Markup Summary

Provide within the Plat Notes the following notes, referenced from the original Plat No. 12864:

AS RE-PLATTED

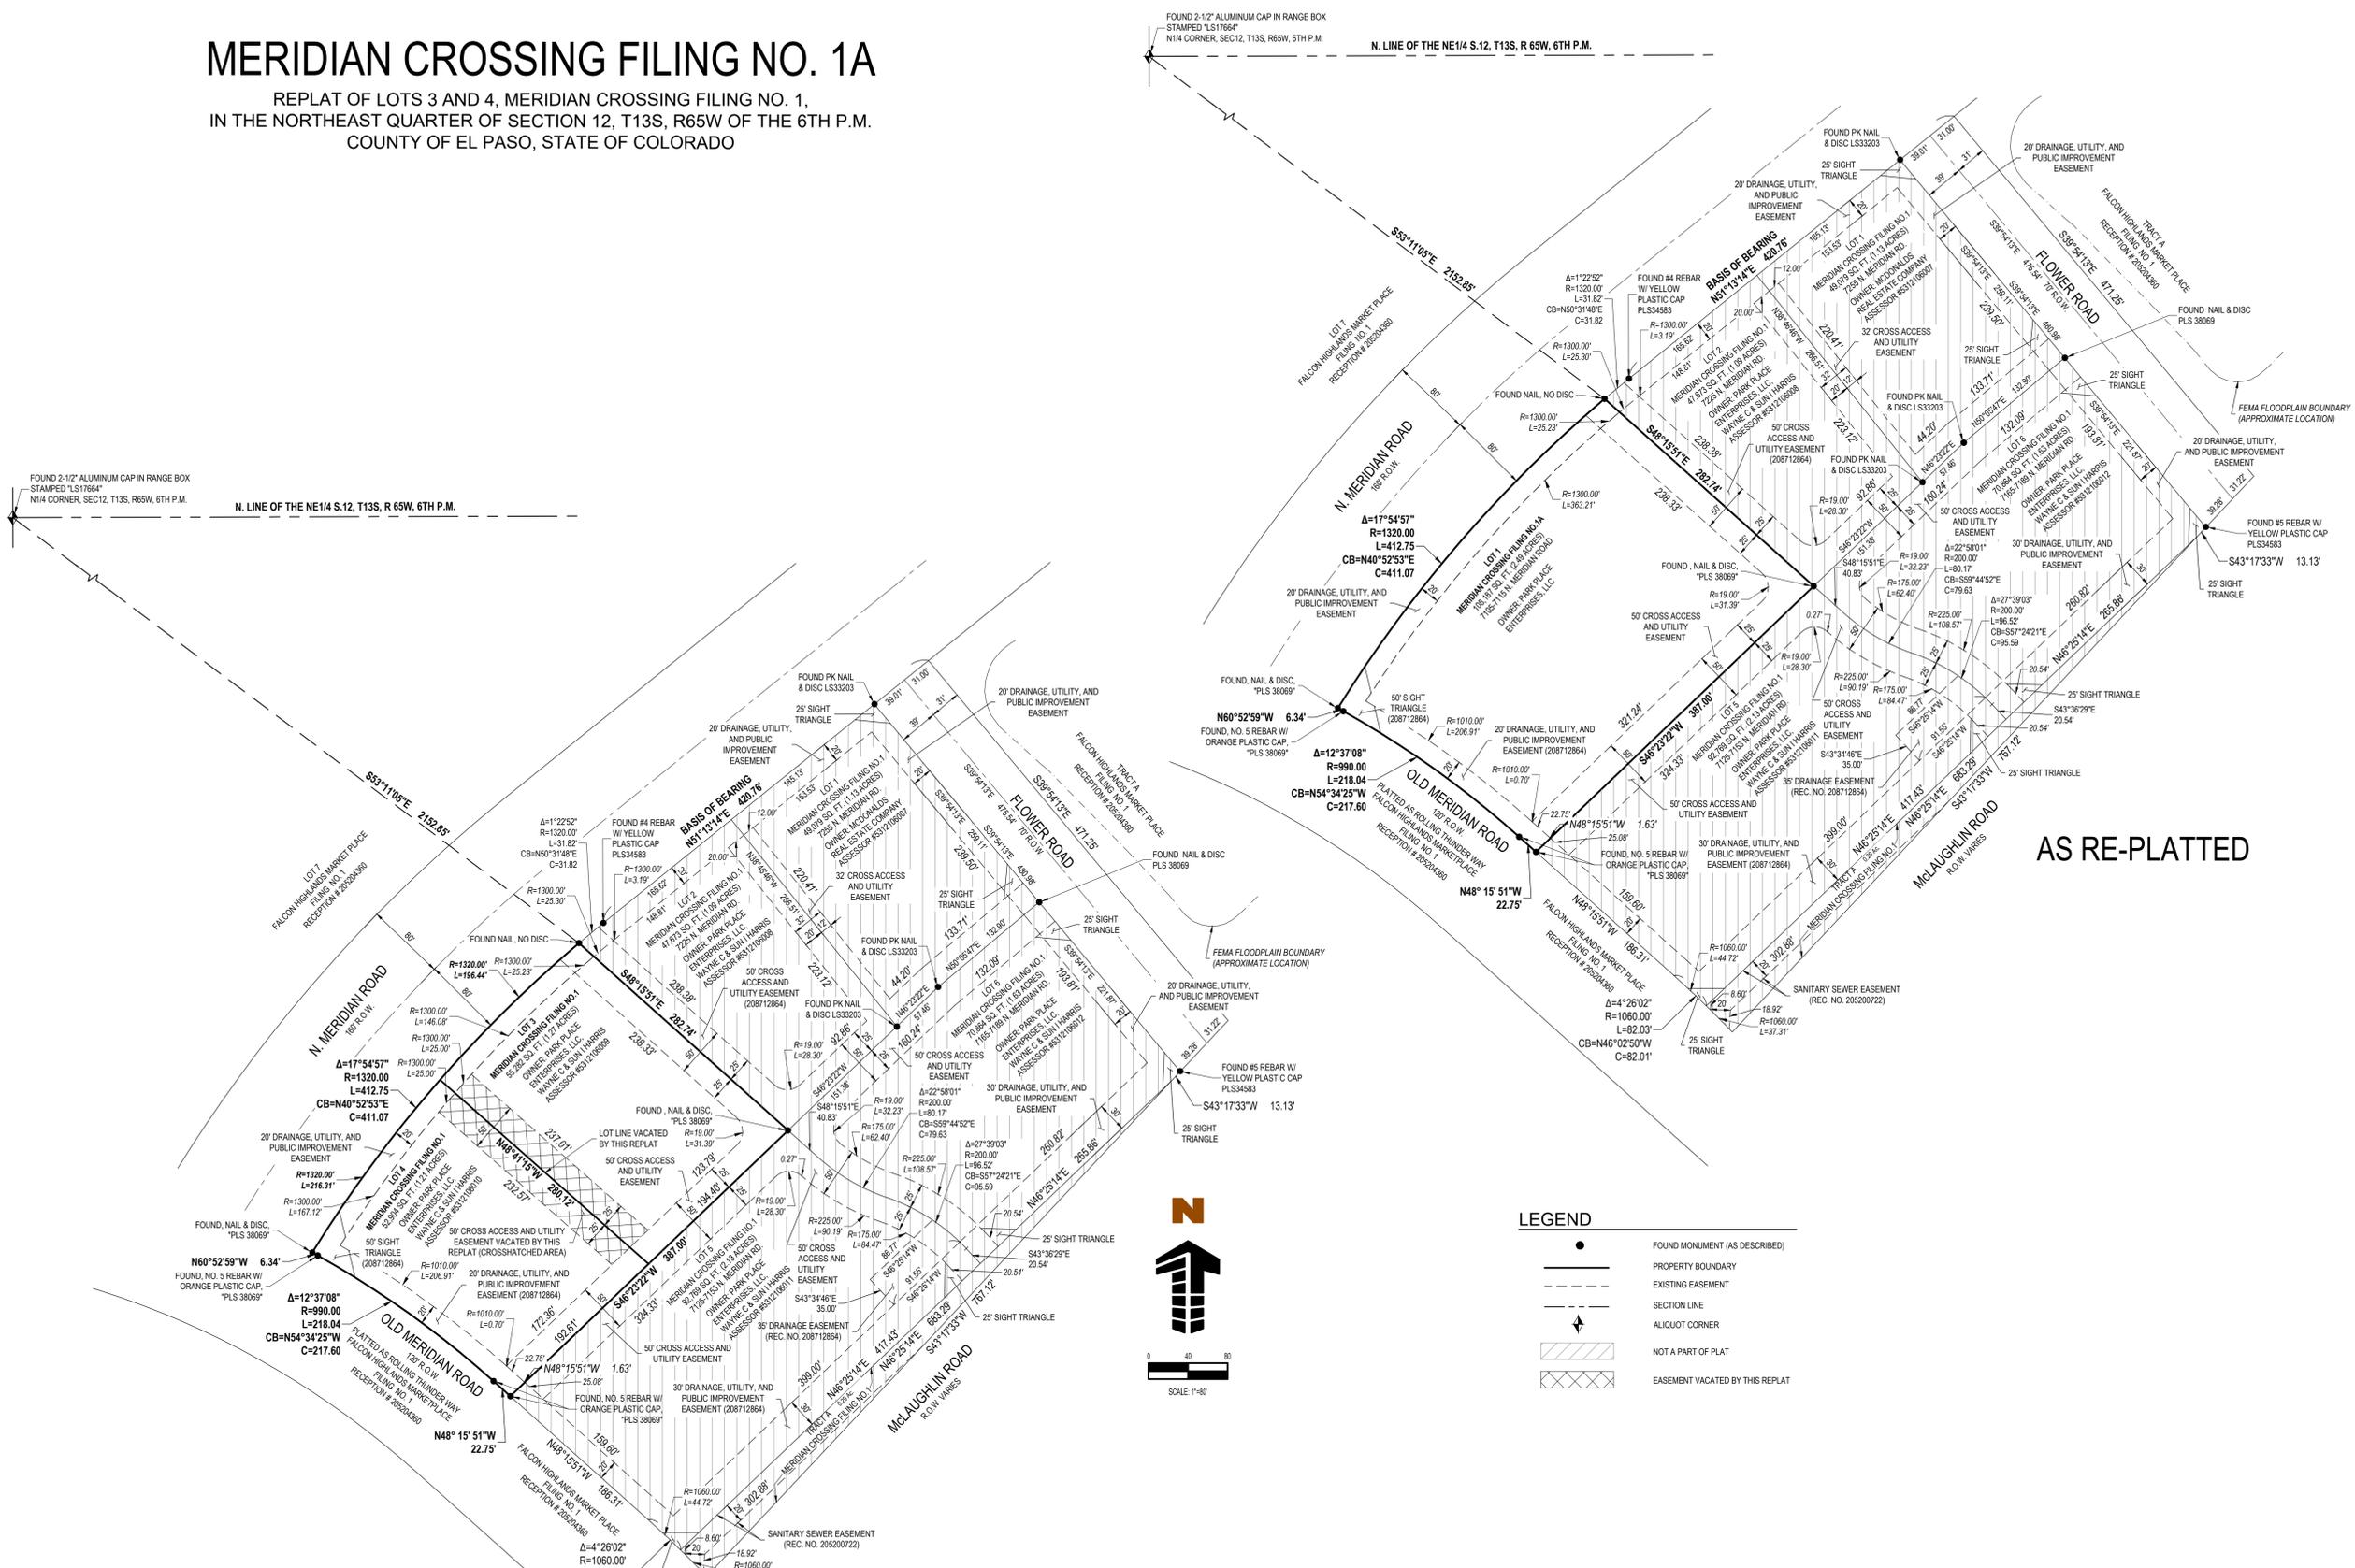
Provide all length dimensions for the existing easements and property boundaries.

Provide the length and radius of each corner in the intersection

Call out 50' access and utility easement

Please show the 35' x 91.55' drainage easement shown on original plat.

Sanitary sewer easement missing with reception number

Provide Lot information or remaining three lots northeast of Lots 1 and 5.

Refer to previous plat, all adjacent property must be labeled, also flood plain has been omitted from this plat

Call out 32' cross access and utility easement

Provide Line of Sight Triangles at all intersections and entrances.

Not as platted, please refer to previous plat and include all information

Call out 30' Drainage, Utility, and Public Improvement easement
